Issue Specific Hearing 10 (ISH10) on Biodiversity and Ecology

Theberton and Eastbridge Parish Council, B1122 Group and Stop Sizewell C

Oral Contribution by Cllr. Paul Collins

DRAWING NO:
SZC-SZ0100-XX-000-DRW-100205

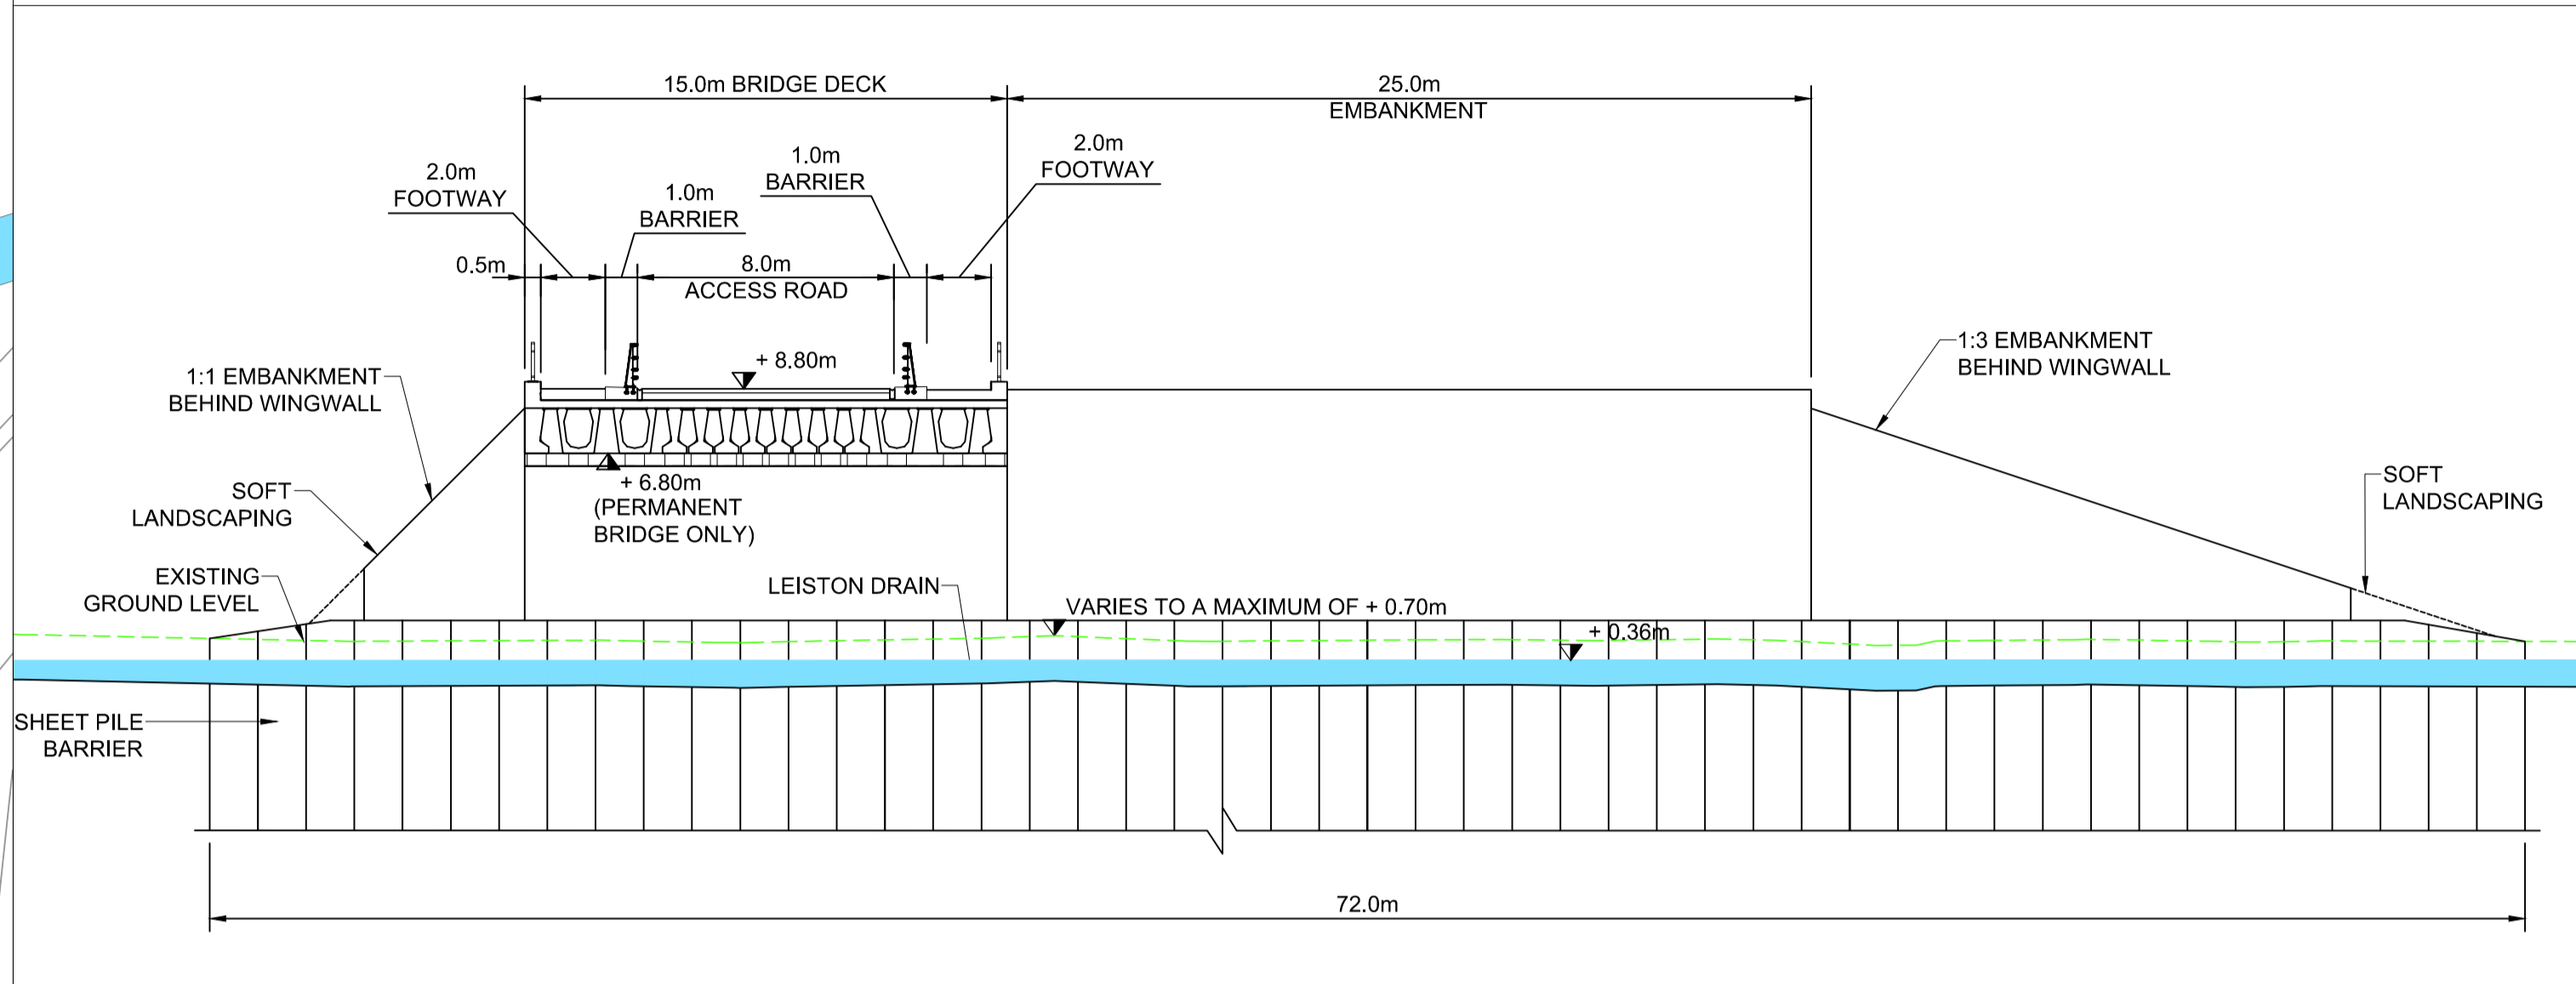
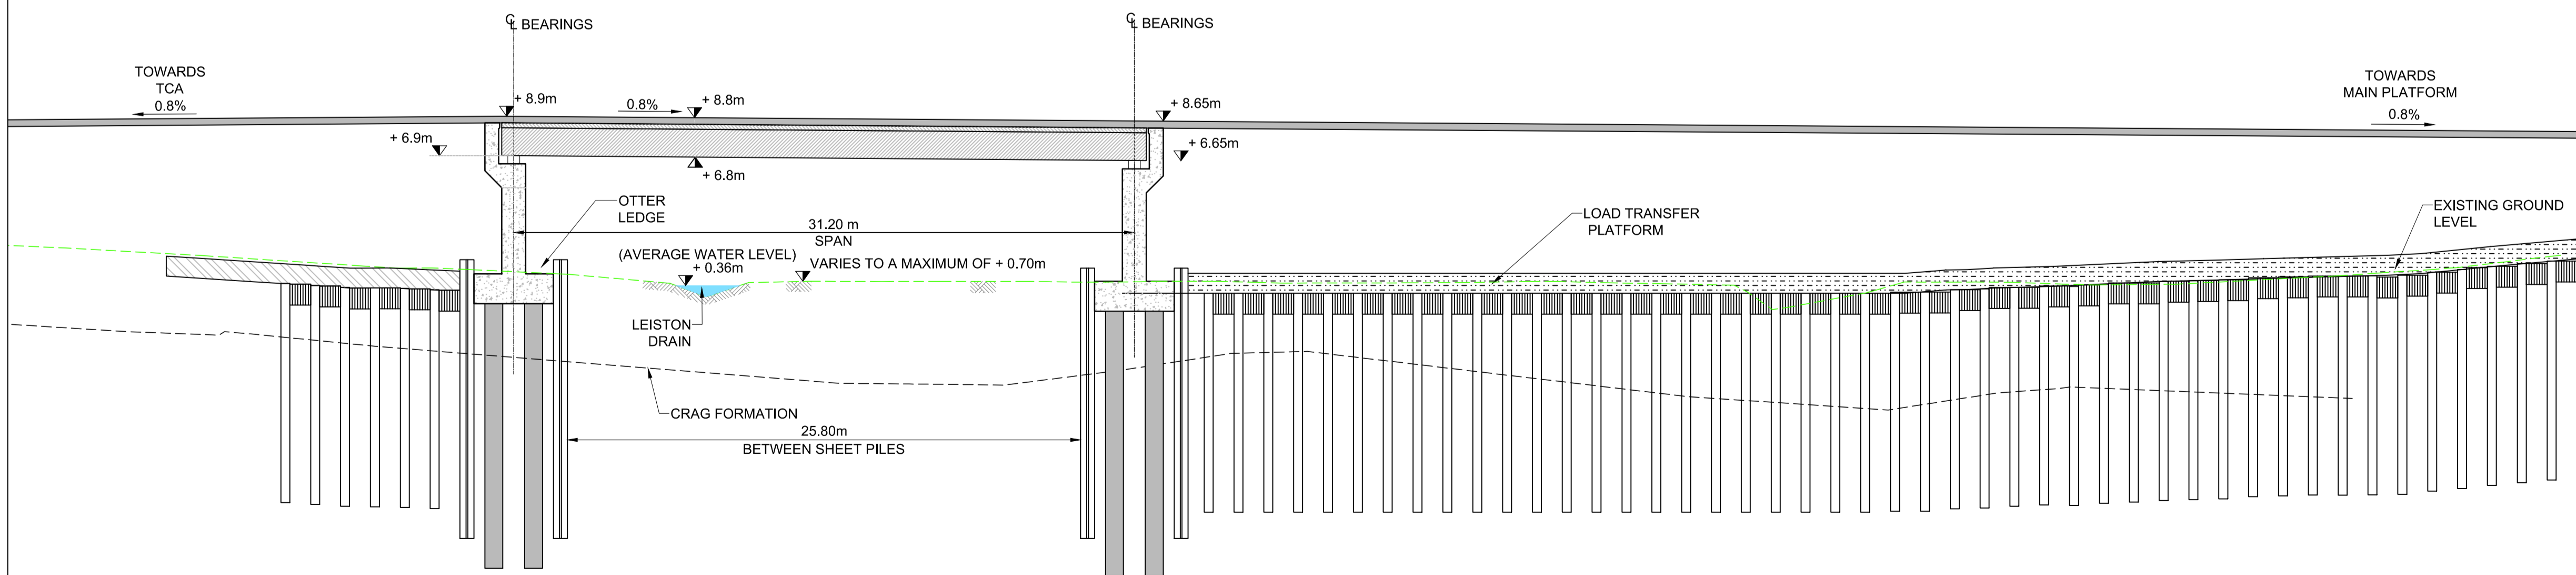
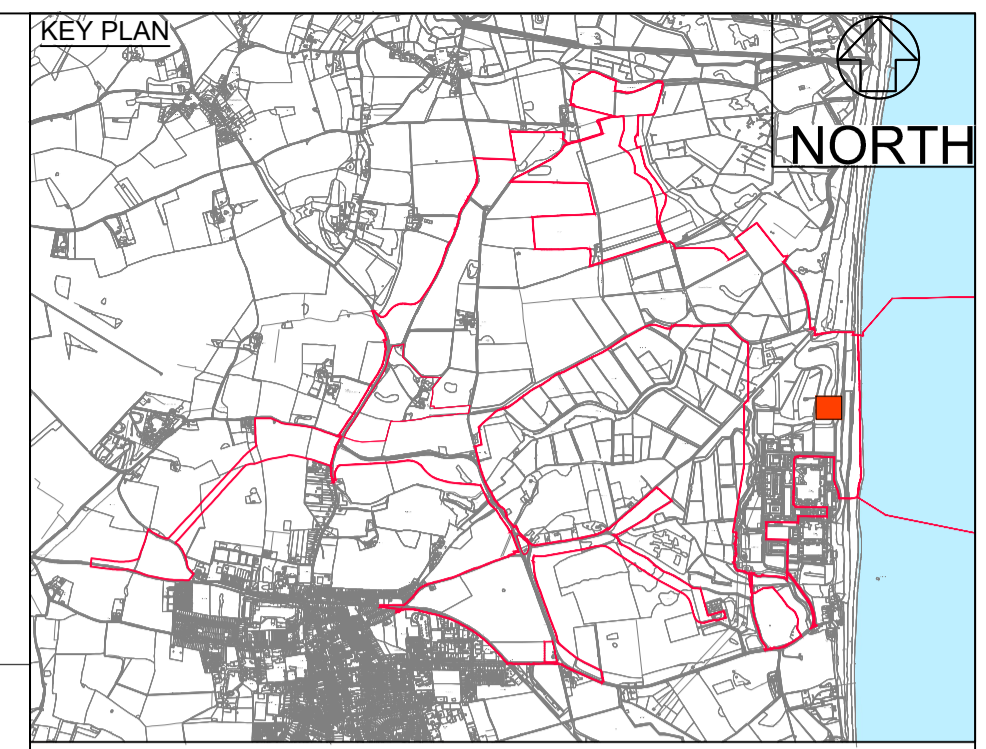
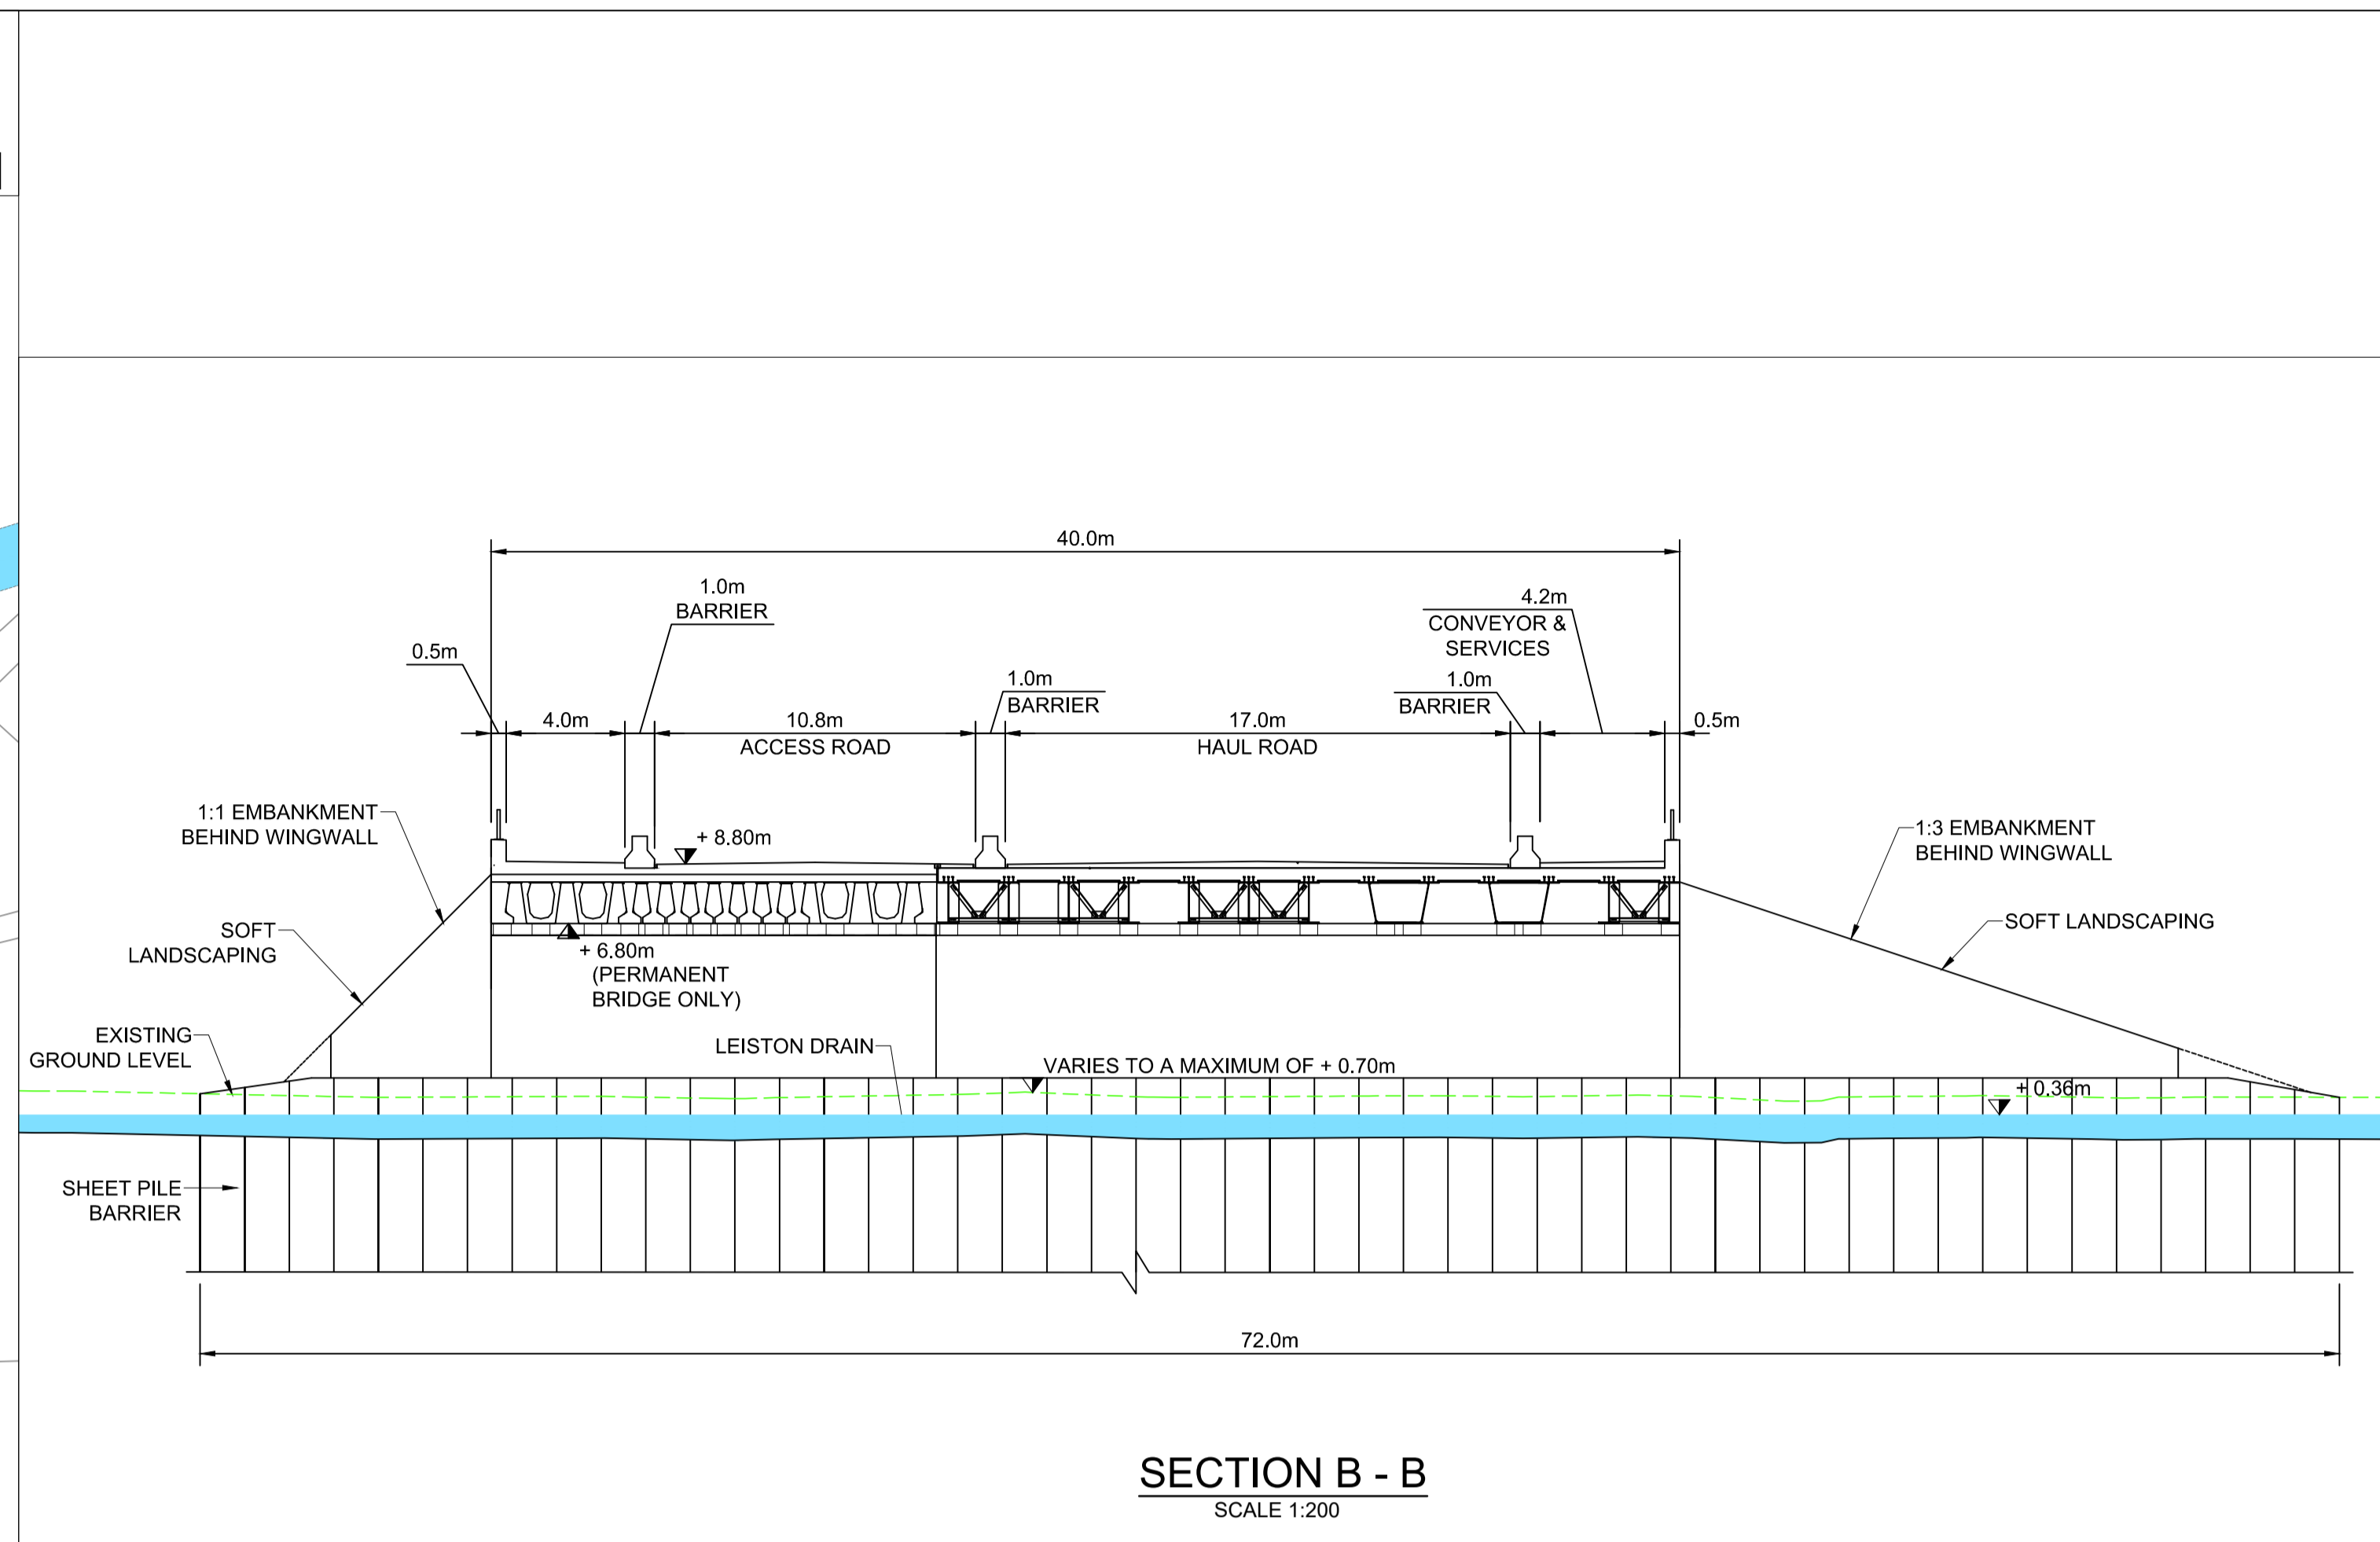
- o ***At all stages the SSSI Crossing structure is surrounded by sheet pile which is inappropriate considering the location within the SSSI and where eventually the restored Sandlings Path long distance route will be.***

The final 1:1 slope to the west of the structure will be completely incongruous in this location and there are concerns that it will not sustain good vegetation cover in the long term.

The concrete wings of the crossing initially supporting both main access and haul road/conveyor access cannot be disguised and are inappropriate in this location within the AONB and at the junction of the two SSSIs and Minsmere's other designations. Once the haul road crossing structure is removed, the concrete wings will become even more obvious in the landscape.

These comments simply go to reinforce the position of Stop Sizewell C and others that a more appropriate design is the 3 span bridge originally proposed at consultation 1.
